OEH –Report on Site Verification Certificate

SVC Application No. 14_6526

Project Name : Warkworth Continuation 2014

OEI INTERIM ASSESSMENT OF BSAL SITE VERIFICATION CERTIFICATE APPLICATION

Soil Units

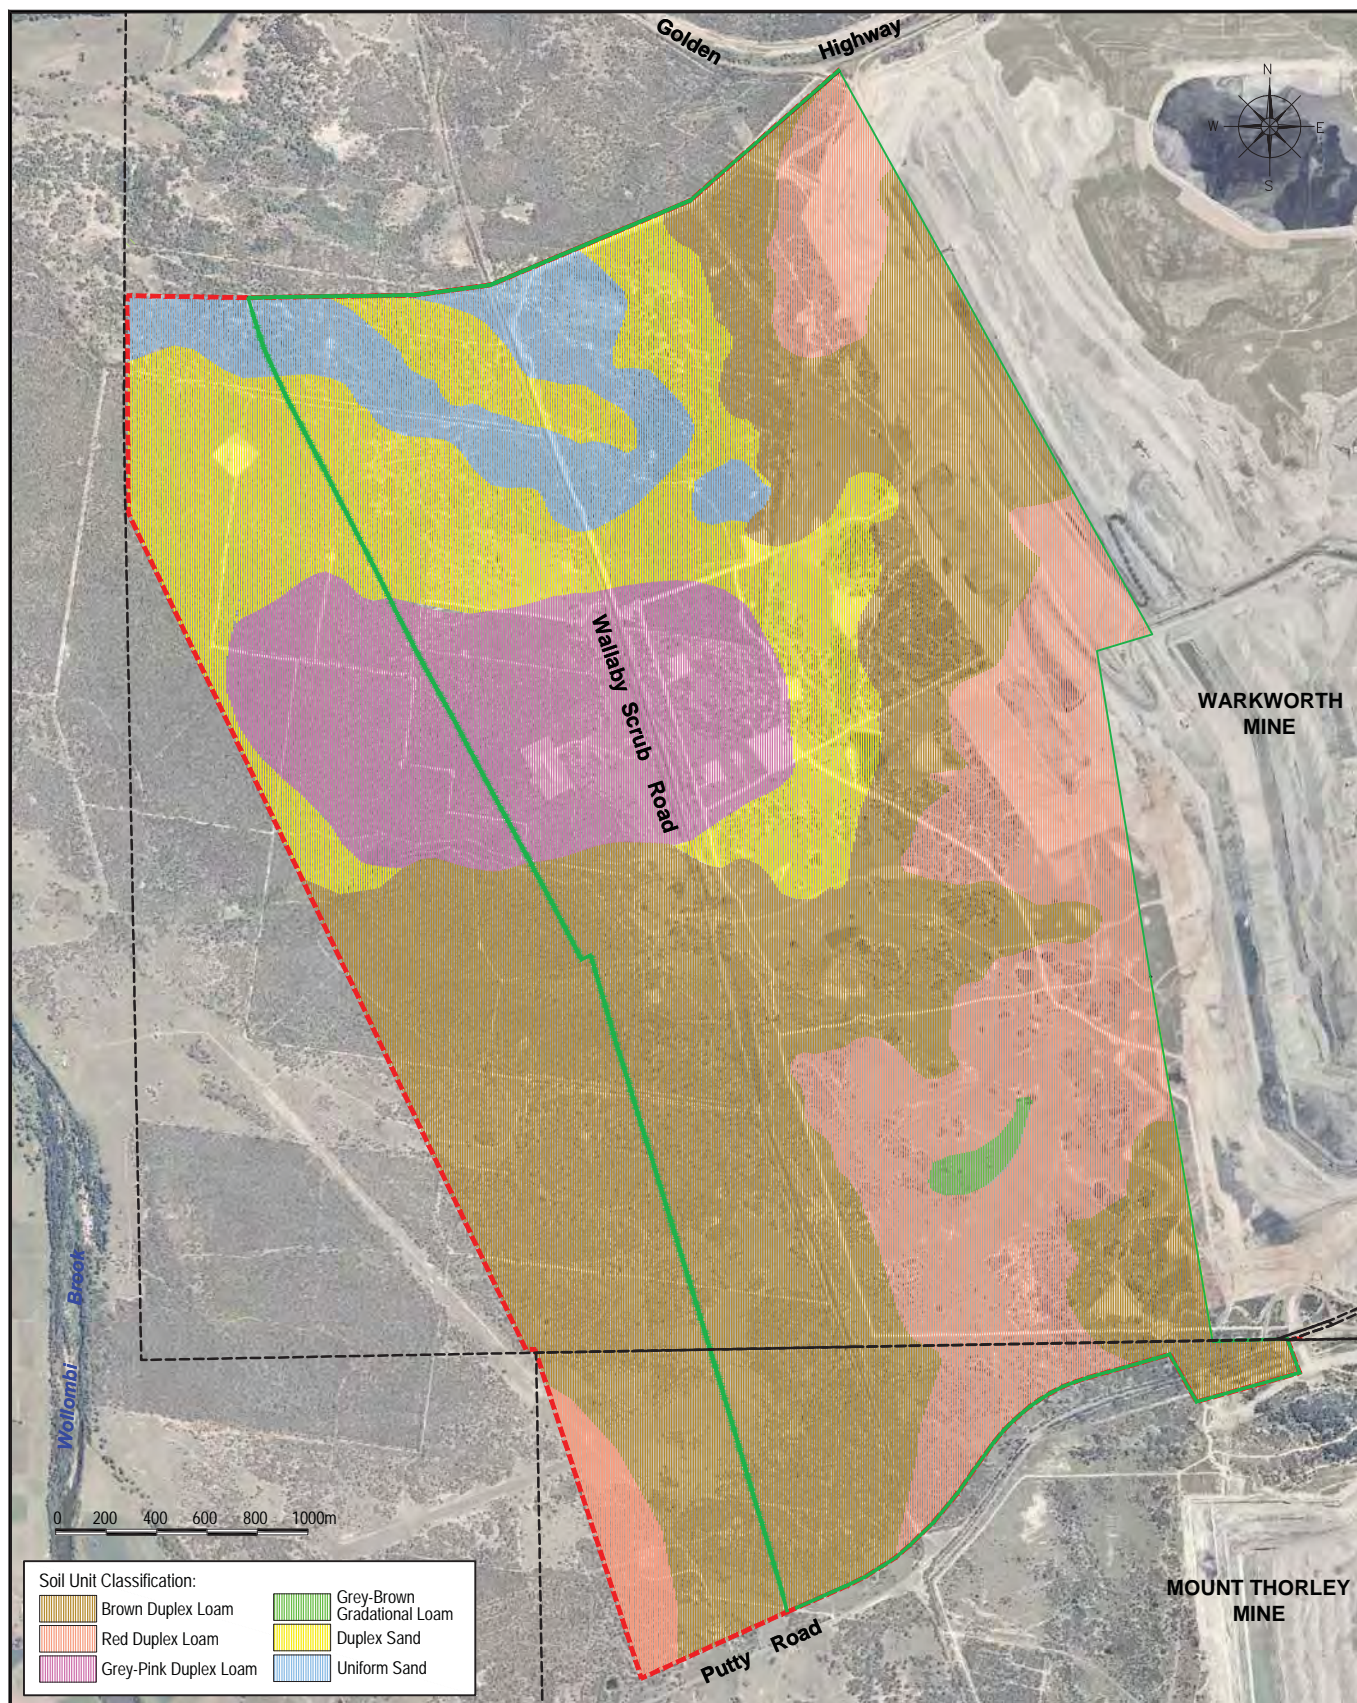
SUMMARY OF ASSESSED ITEMS	Appropriate as per the Protocol		Justification
	Yes	No	
PERSONNEL			
Evidence provided by the applicant that a qualified soil scientist oversaw the verification assessment and signed off on the quality and extent of the work	X		The project was oversighted by Dr Timothy Rohde, a Certified Practising Soil Scientist (CPSS, Stage 2) with the Australian Society of Soil Science Inc.
MAPS			
Geographically accurate base map (at 1:25,000) of assessment area supplied as per Protocol. Spatial dataset (boundary of assessment area) supplied in GIS format as per <i>Interim Protocol</i> .	X		GIS data supplied 14 th May 2014.
Soil map (at 1:25,000) of project area supplied including all observation (Detailed, Check and Exclusion) sites as per Protocol. Spatial datasets (soil map, observation sites and data reliability/data source diagram) supplied in GIS format as per <i>Interim Protocol</i> .	X		GIS data supplied 14 th May 2014. No data source/data reliability diagram, and no evidence that soil map includes >100 m buffer on soil map. Soil map does not include a ~70 m (max) wide strip of land at the N end of the application area.
